ENG-SP19003-R3-PDR-redlines.pdf Markup Summary

Cursory comments. See comment letter also.

PROPOSED
DRAINAGE MAP

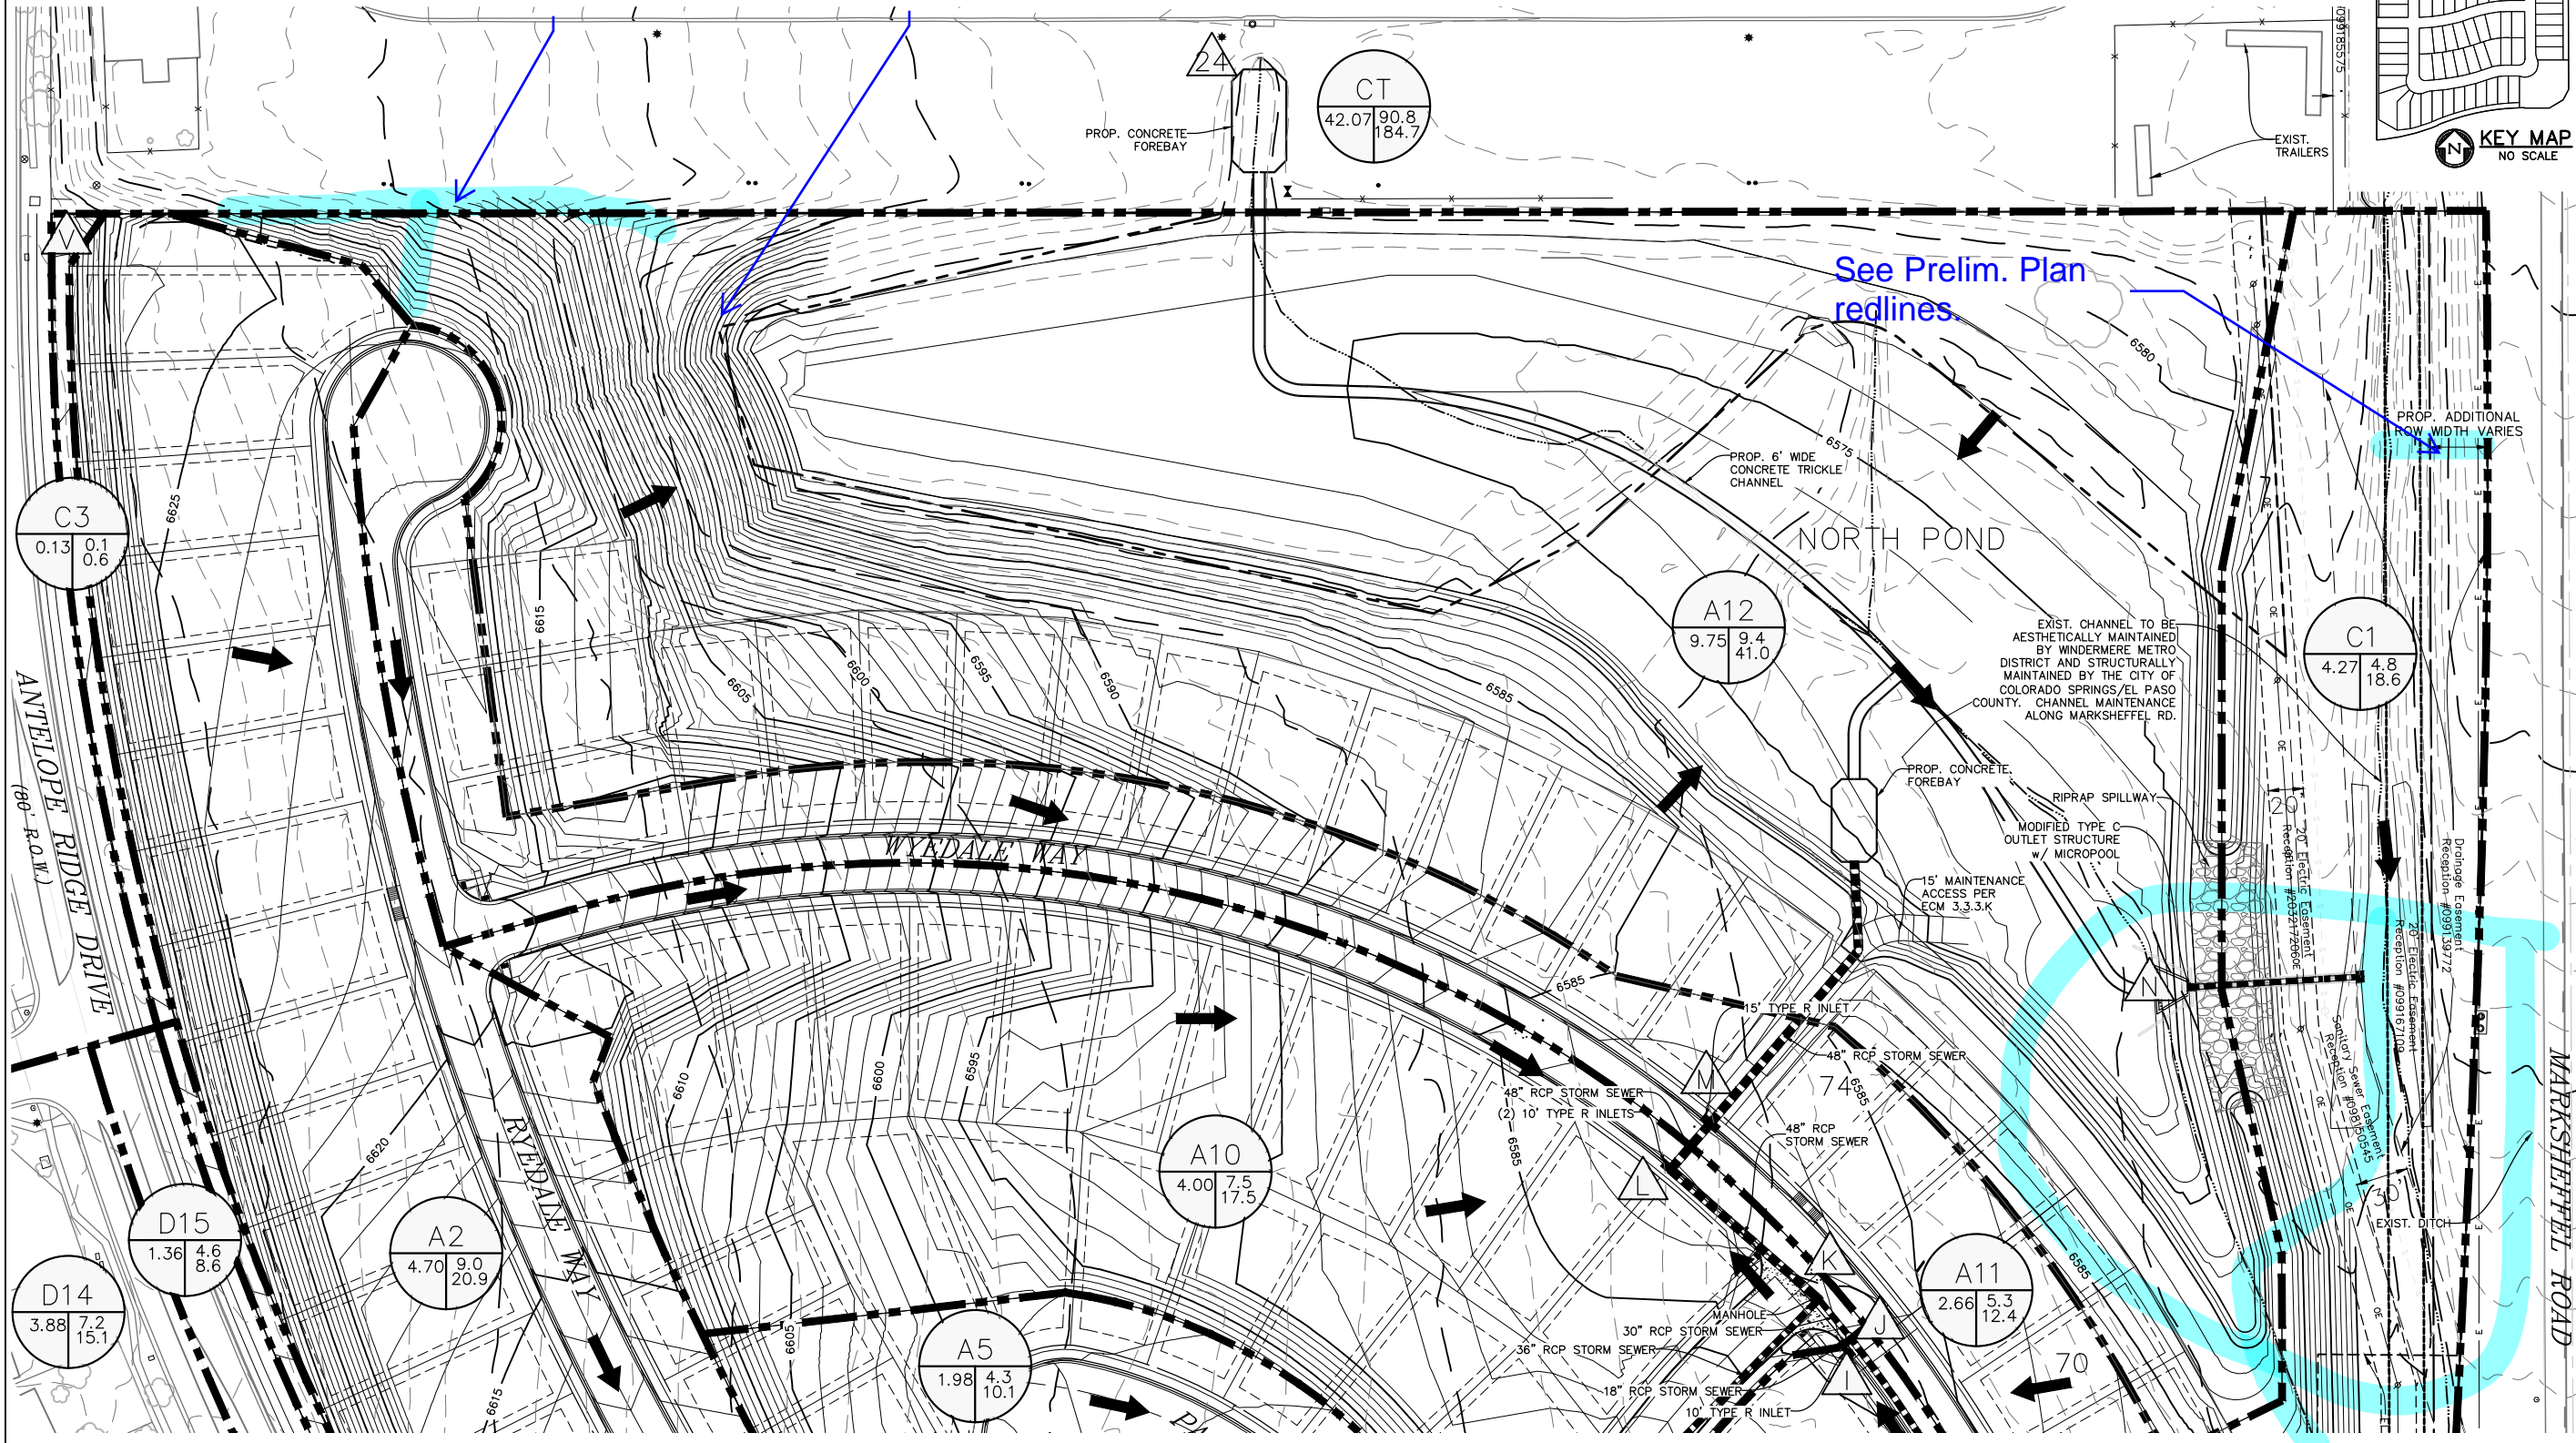
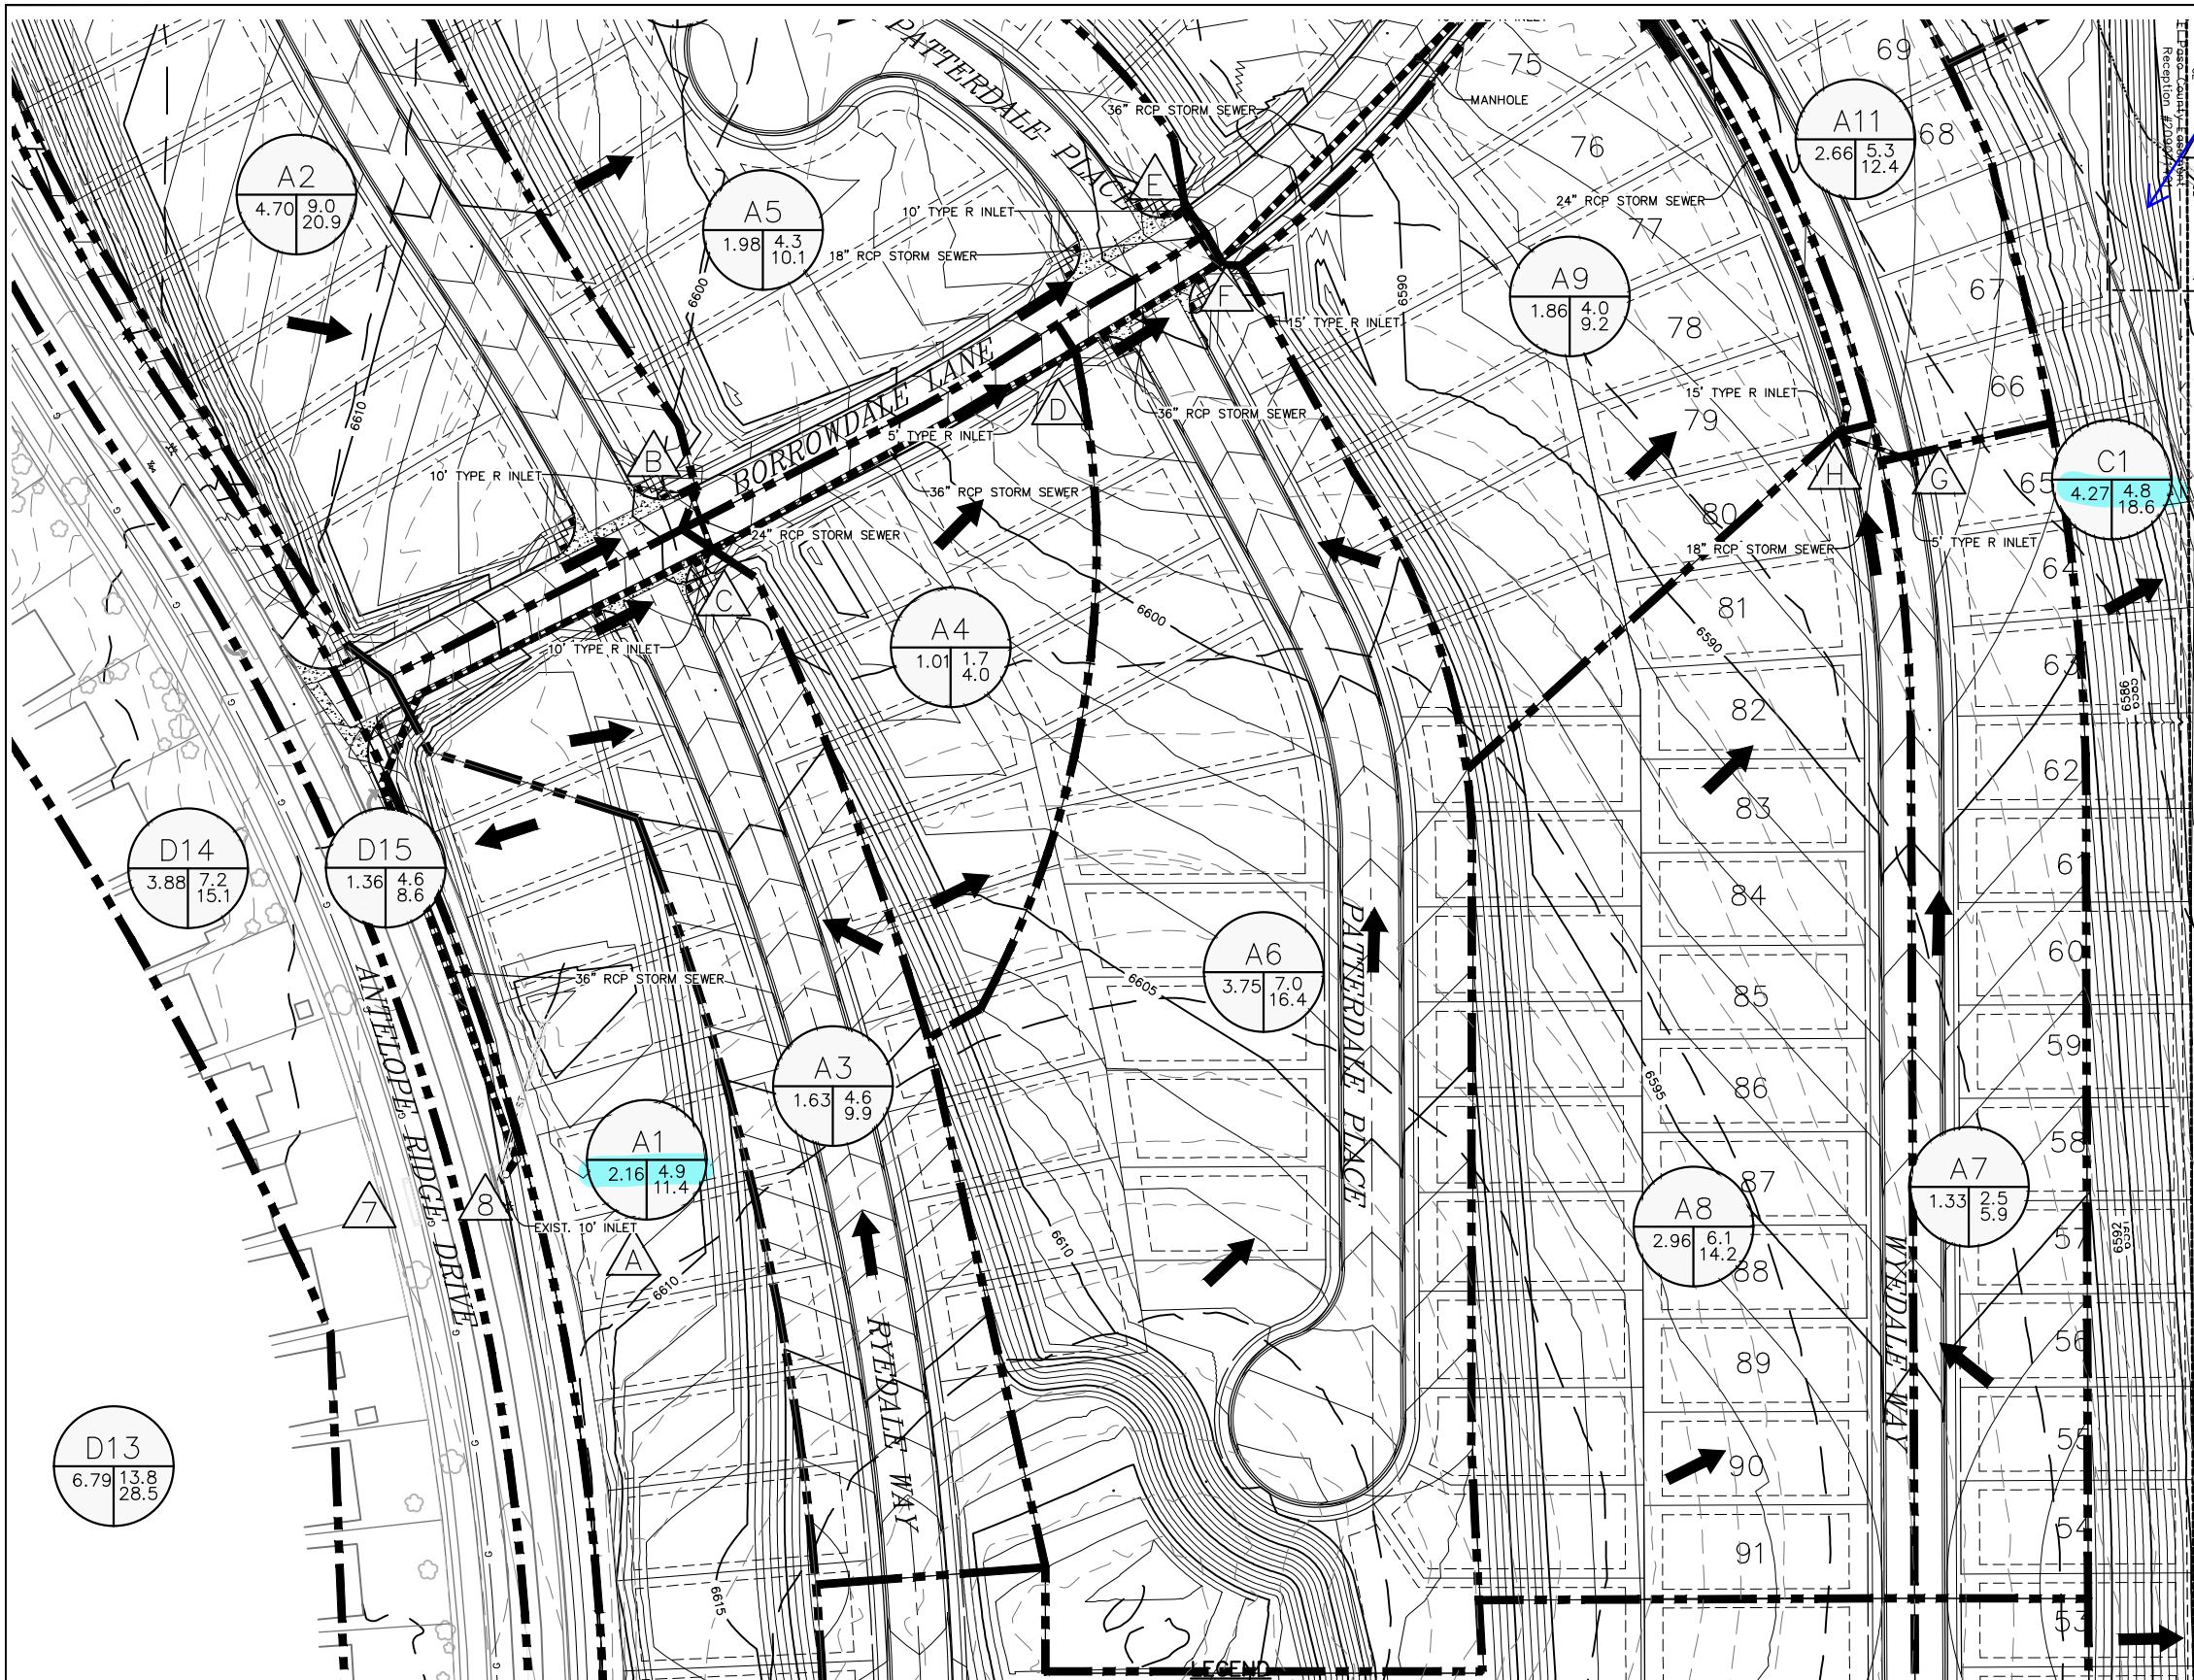
Provide stabilized rundown

Offsite swale with easement?

See Prelim. Plan redlines.
